My Ref: 2020/1450 (2020/0946)
Date: 09/02/2021
Enquiries to: Richard Gilbert
Direct Dial: 01226 772108
E-Mail: richardgilbert@barnsley.gov.uk

Proposal Description: Details of conditions 4 (boundary treatments), 8 (landscaping), 9 (EVC's) and 10 (Trees) of planning permission 2020/0946 - Change of use of A4 public house to wardrobe showroom and workshop at ground floor (sui-generis) along with erection of a single storey 100 sq. m ground floor extension to the rear and change of use of first floor to 1 No. C3 residential flat.

Location: Hope Inn, Rotherham Road, Cundy Cross, Barnsley, S71 5QZ

Drawing: Proposed Site Plan 2 Dwg No: 009

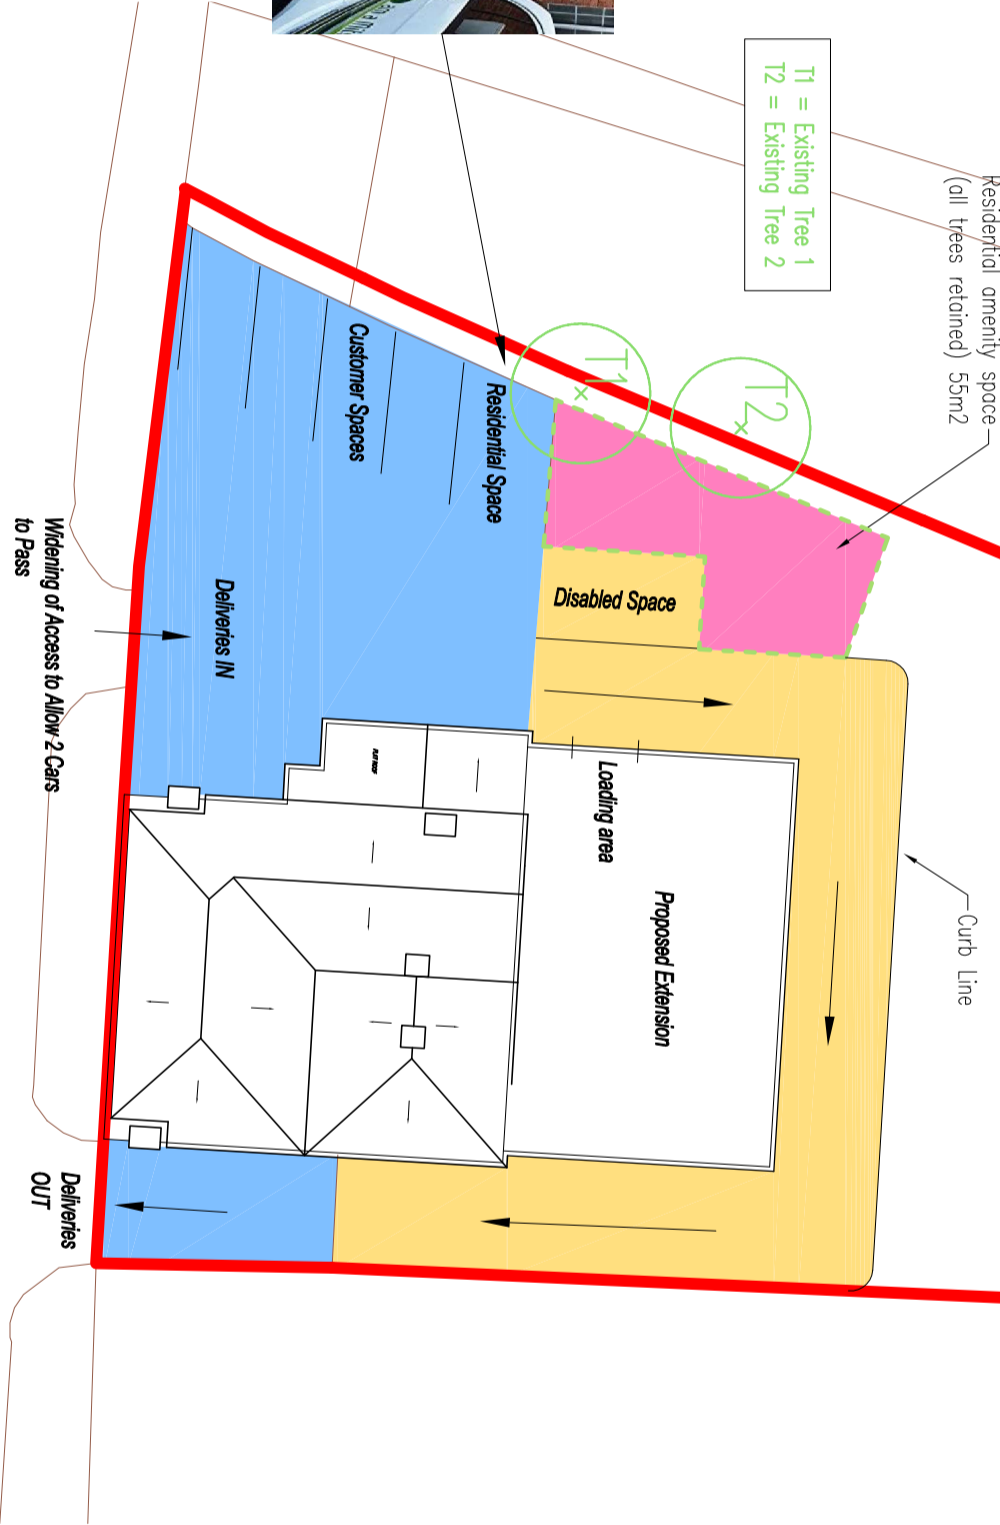
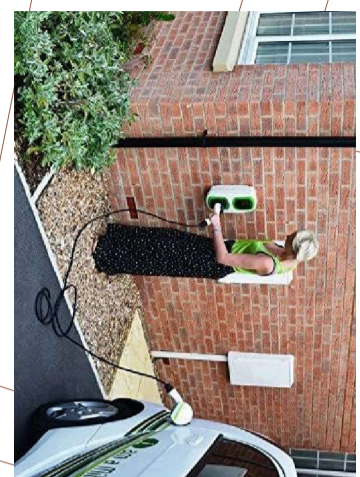
The details of Condition 8 supplied on 'Proposed Site Plan 2 – 009' are determined as satisfactory in respect of the amenity space and turning area – the parking area is subject to the details required in C10. However the plan remains silent on the area within the red line boundary to the north of the site. The LPA is aware that this area has been subject to burning of materials and is generally unkempt prior to occupation of the Hope Inn. The area is also visible through the palisade fence and the purpose of the condition was to understand how this area is to be managed aesthetically. Given the business operation on site it was understood some storage of materials may take place and it will be necessary to provide these details on an amended site plan. The condition is therefore partially discharged subject to further information being supplied.

Project : The Hope Inn, 29 Rotherham Road, Barnsley, S71 5QZ		Dwg No: 009
Drawing: Proposed Site Plan 2		
Date: 4.12.20	Scale : 1:200 A1	Rev: 0

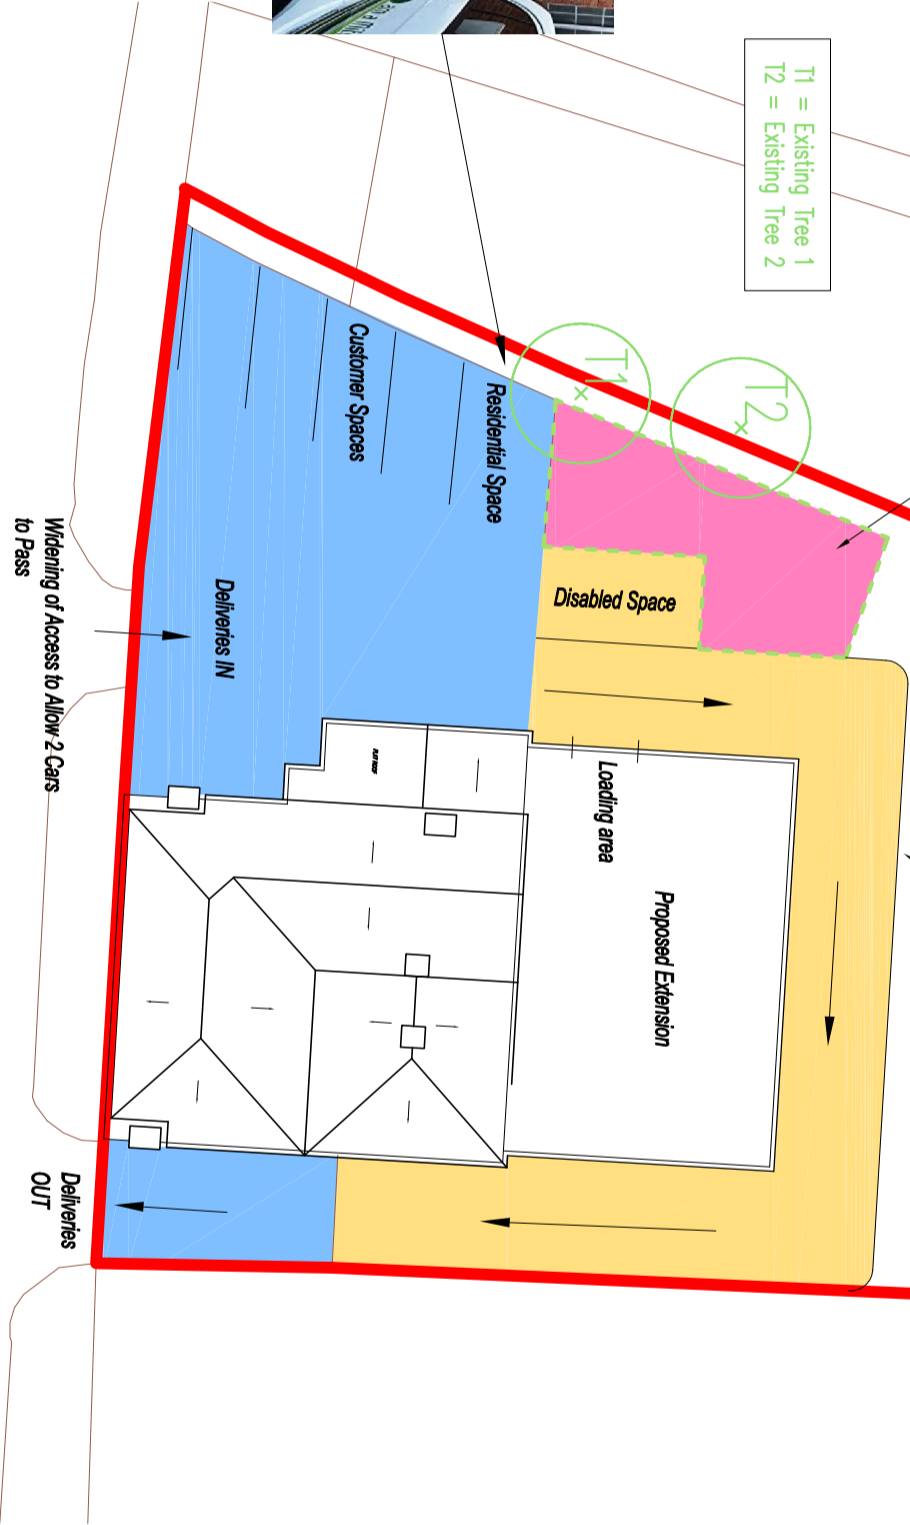
The details of Condition 4 supplied on 'Proposed Site Plan 2 – 009' are determined as satisfied and the condition discharged. The 2.0m close-boarded timber fence shall be installed in the location identified on the cited plan.

No details of a specific charger have been supplied, no confirmation of an order and no details of how the charger is to be installed have been submitted. The LPA is therefore sceptical that a charger will be installed in line with the submitted details without such details being provided. The condition remains outstanding.

It is accepted that the impact of the close-boarded fencing will be limited, but no method statement detailing how groundworks will be undertaken in proximity of the trees is provided. The tree protection plan also does not indicate where the tree protection is to be located. The condition remains outstanding until documents conducted in line with 5837:2012 are supplied.
